GRADING AND EROSION CONTROL PLANS

THE COMMONS AT FALCON FIELD

EPC STORMWATER REVIEW COMMENTS
IN ORANGE BOXES WITH BLACK TEXT

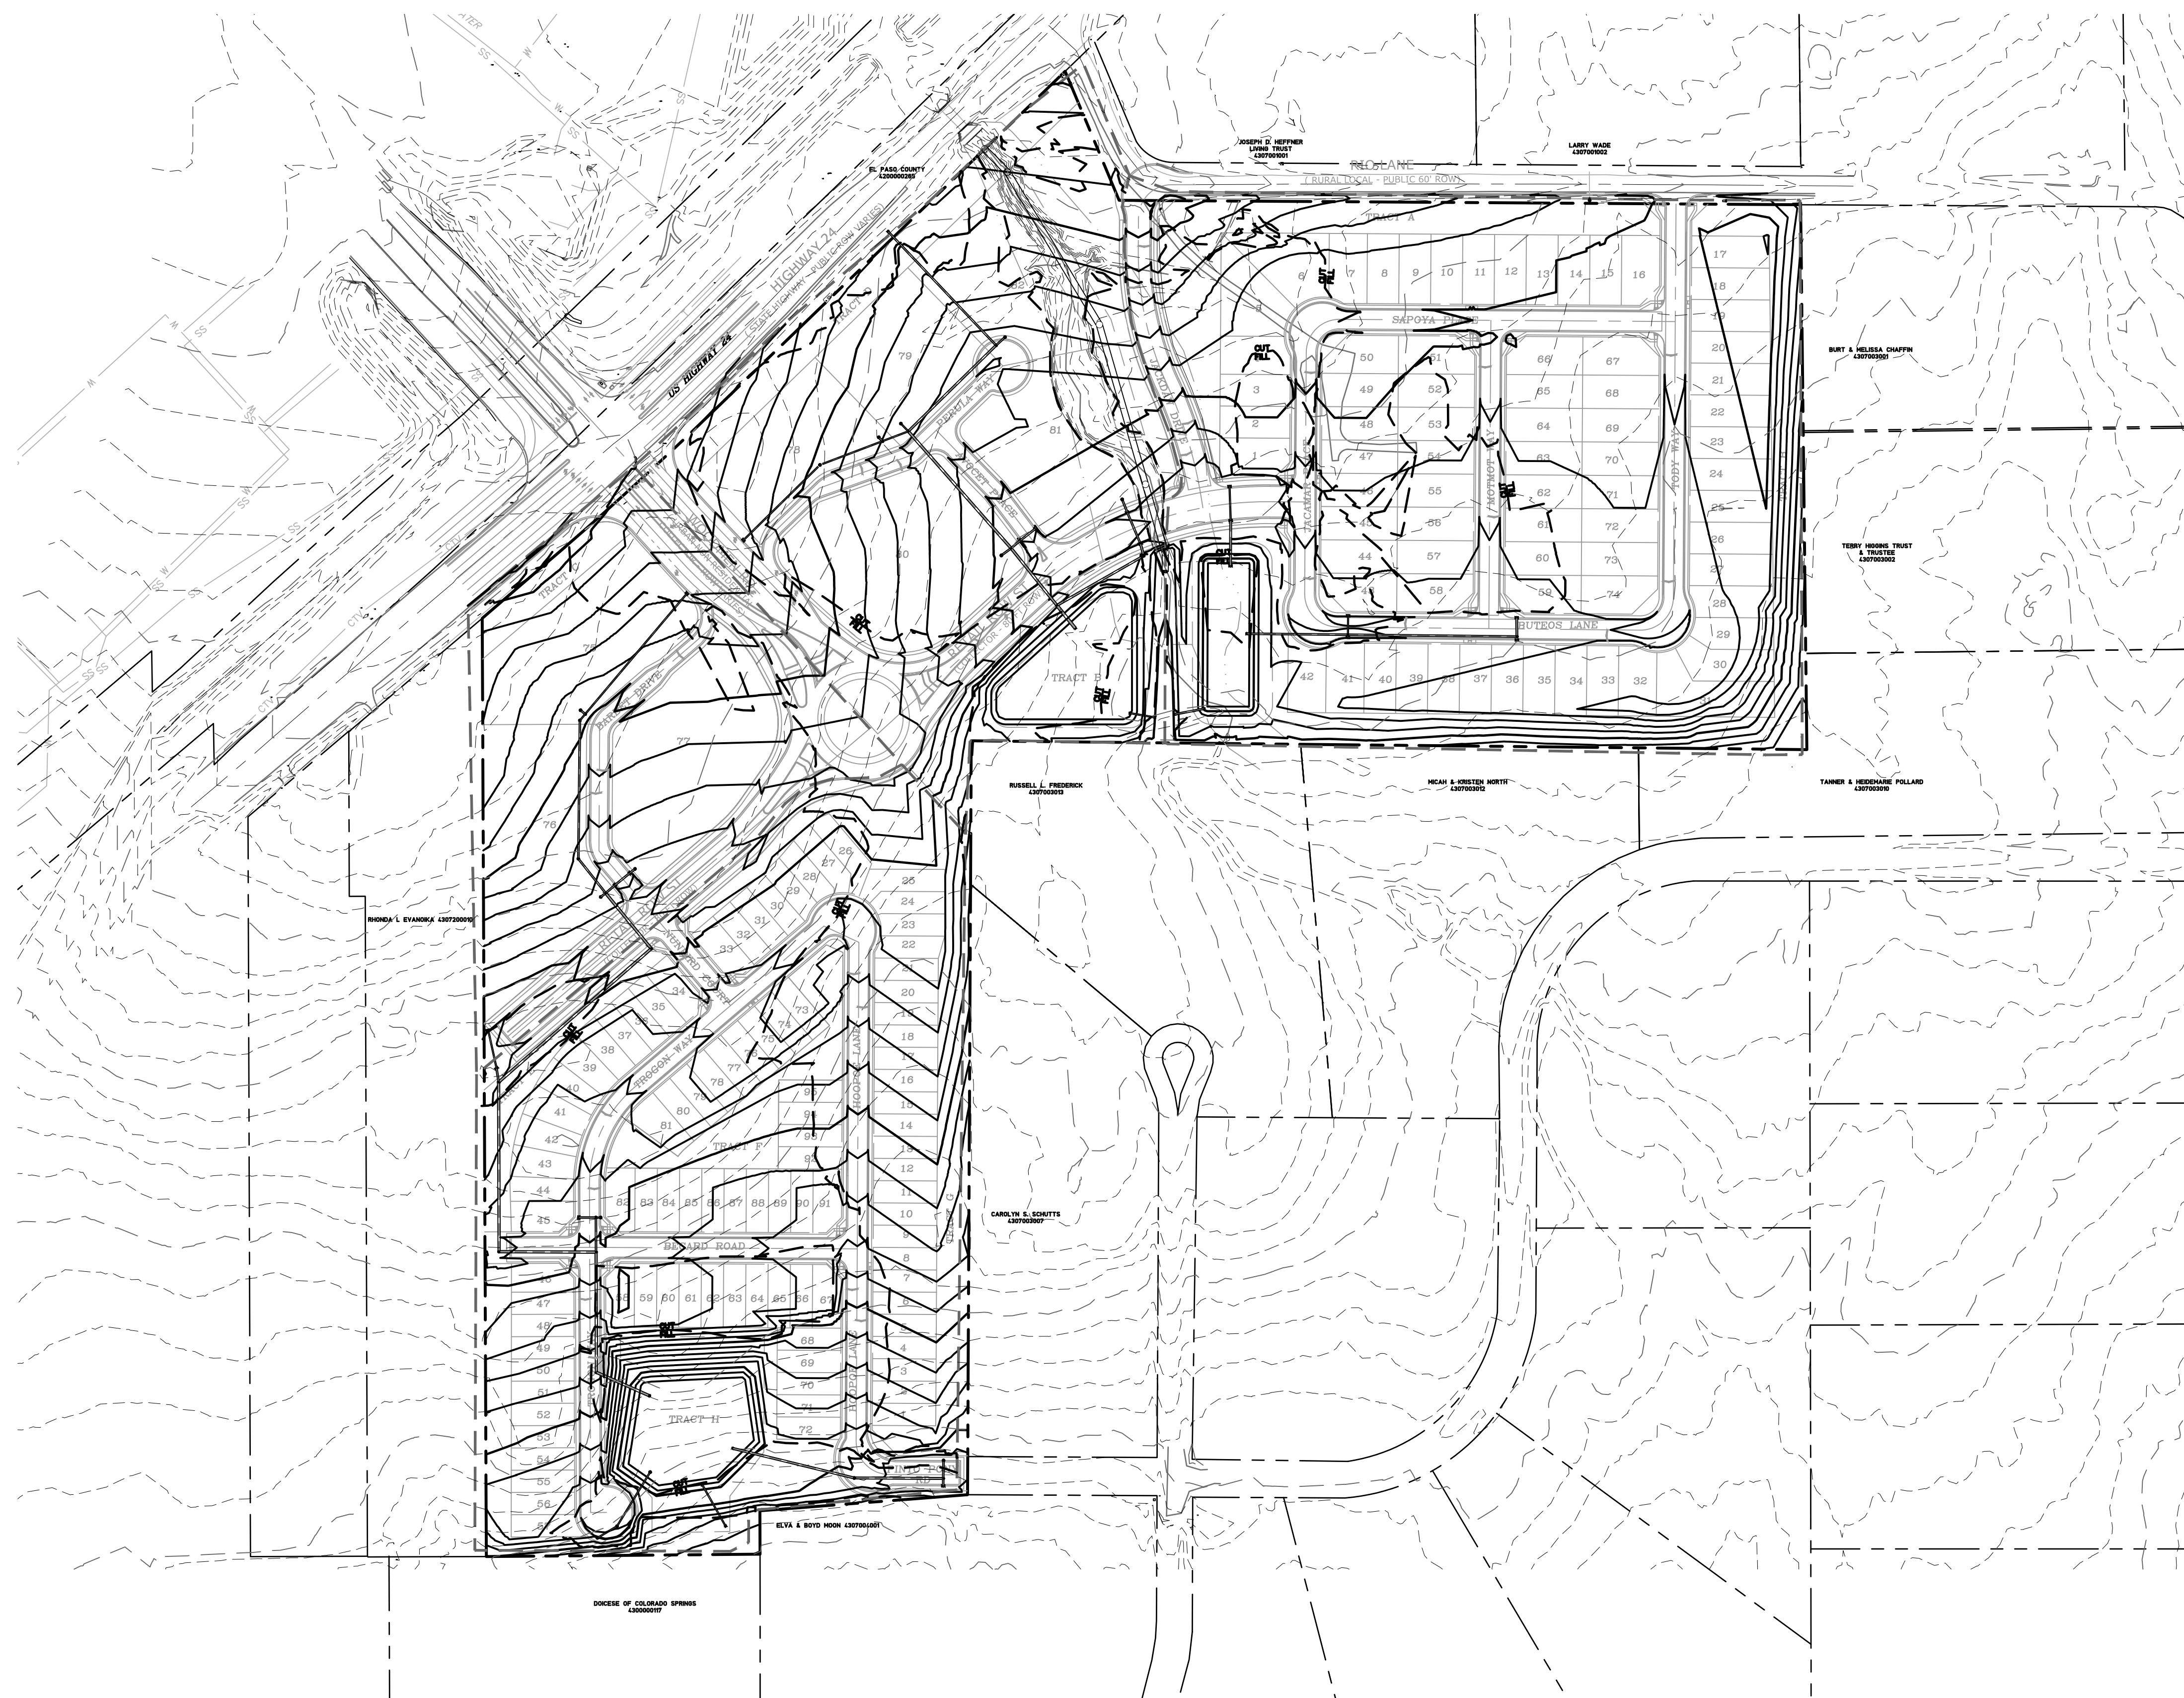
Clarify whether approval for pre-subdivision site grading is being requested. (Other documents say it's not.)

Update standard notes for EPC Grading and Erosion Control Plans. Some of the highlighted notes are in the wrong order or do not match the current standard notes. See current GEC Checklist for current notes.

Provide the horizontal and vertical datum.

Update statement to match the GEC Checklist statement.

Add last paragraph to signature block shown in the GEC Checklist.

Show 100-yr floodplain
linestyle in legend.

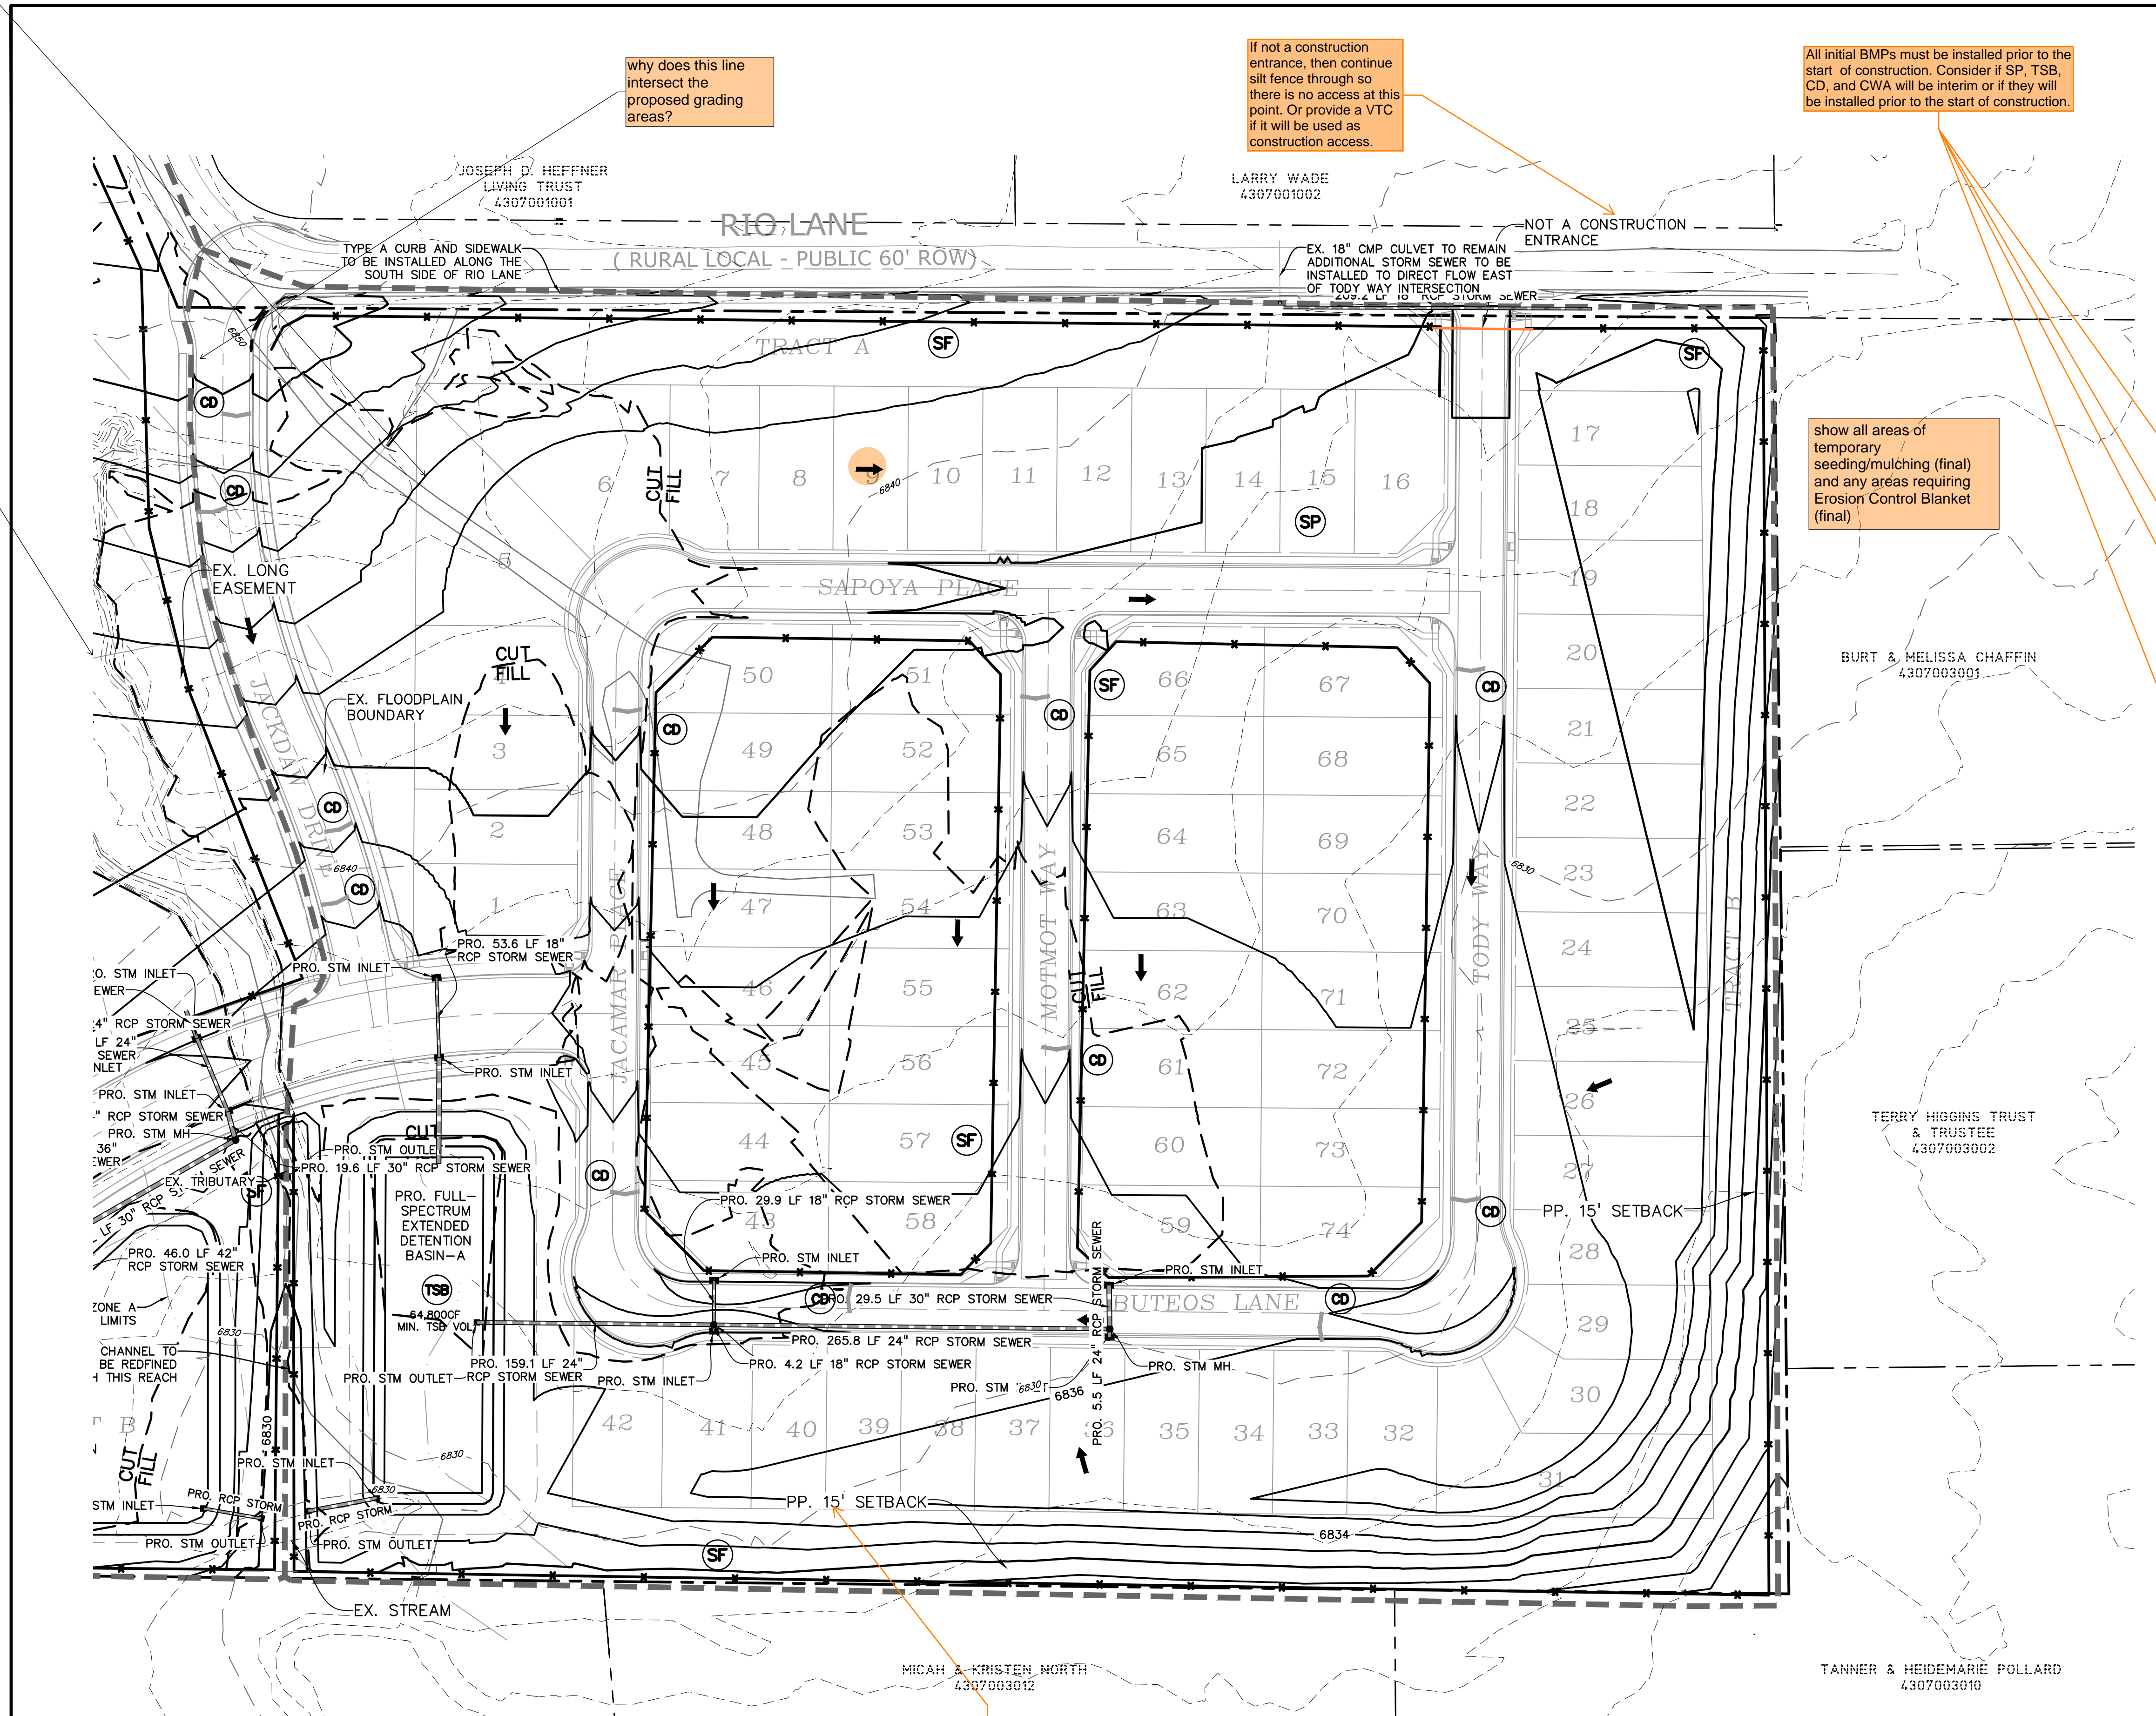
SWMP Checklist Item 4 & 5. Show and clearly label final stabilization measures on GEC Plans.

GEC Checklist Item i: Show existing vegetation or add a note. Typical for all GEC plan sheets.

Provide temporary sediment ponds for disturbed drainage areas greater than 1 ac per GEC Checklist and SWMP discussion.

Per SWMP, add surface roughening or note regarding surface roughening to the plans per the SWMP text discussion.

GEC Checklist Item V. Label all proposed temporary construction BMPs by phase of implementation (initial, interim, final). True for all sheets.

# EC-1

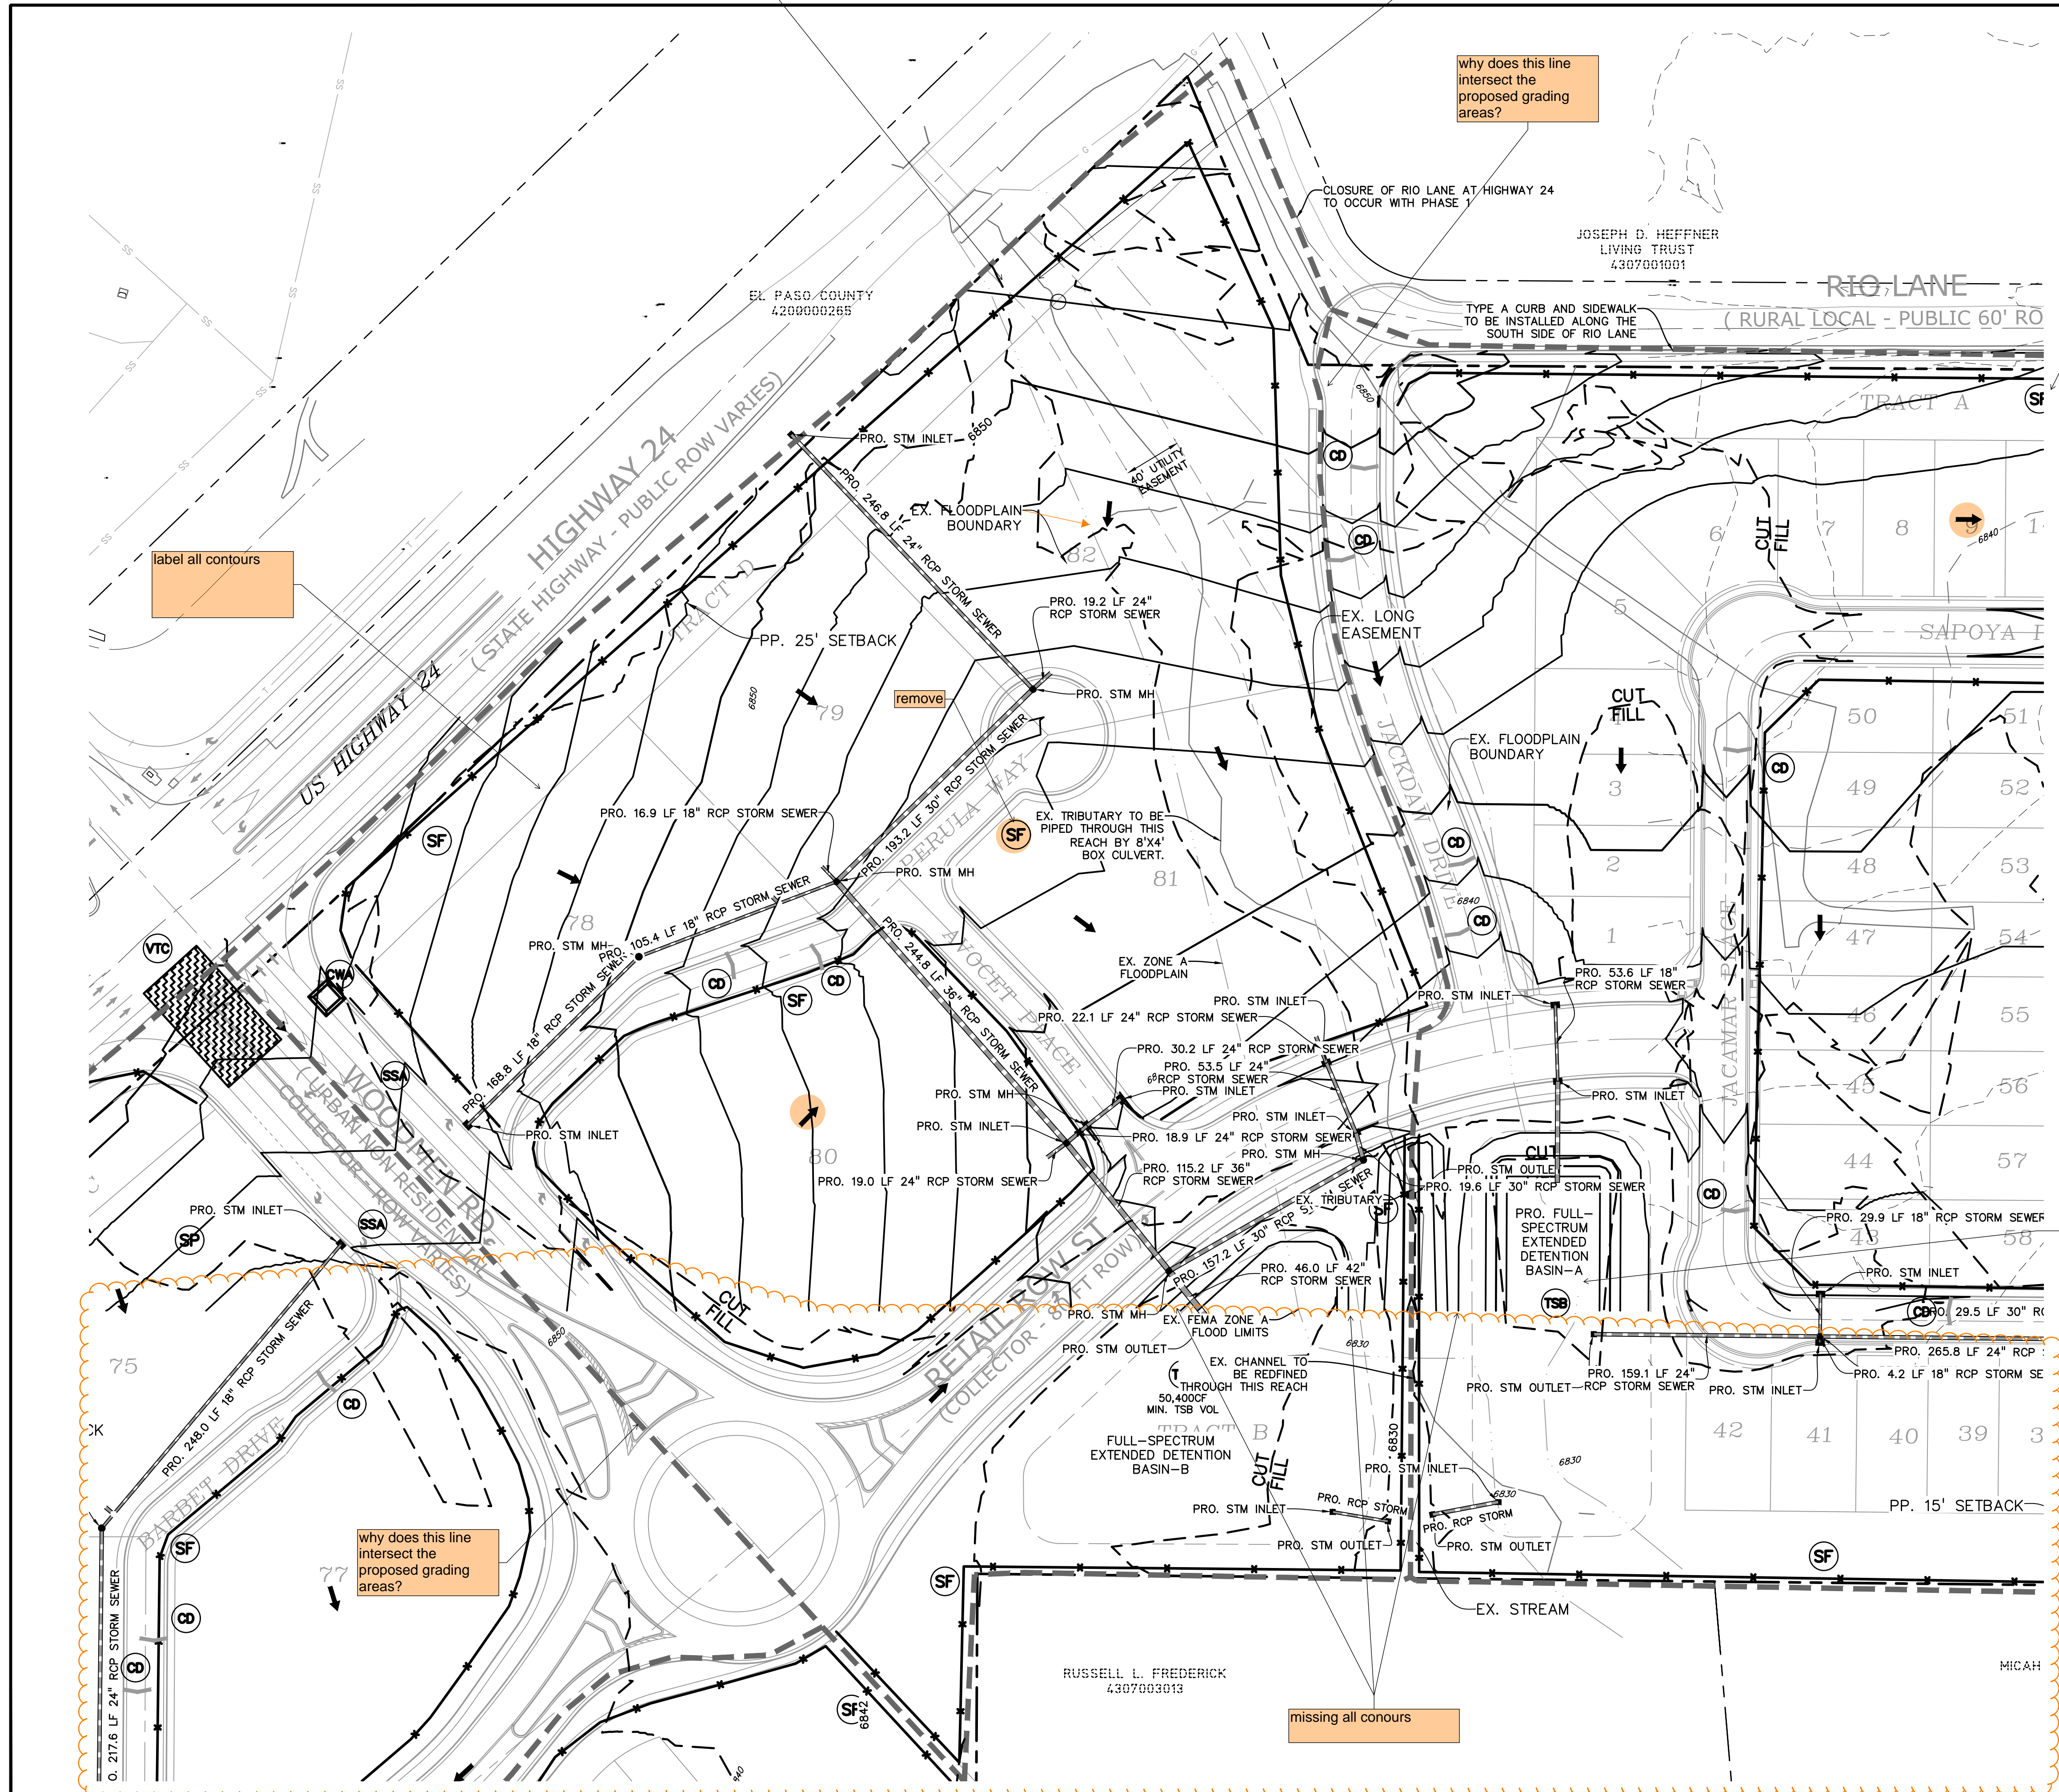
Label existing and proposed water course. Typical comment for all sheets per Checklist Item k.
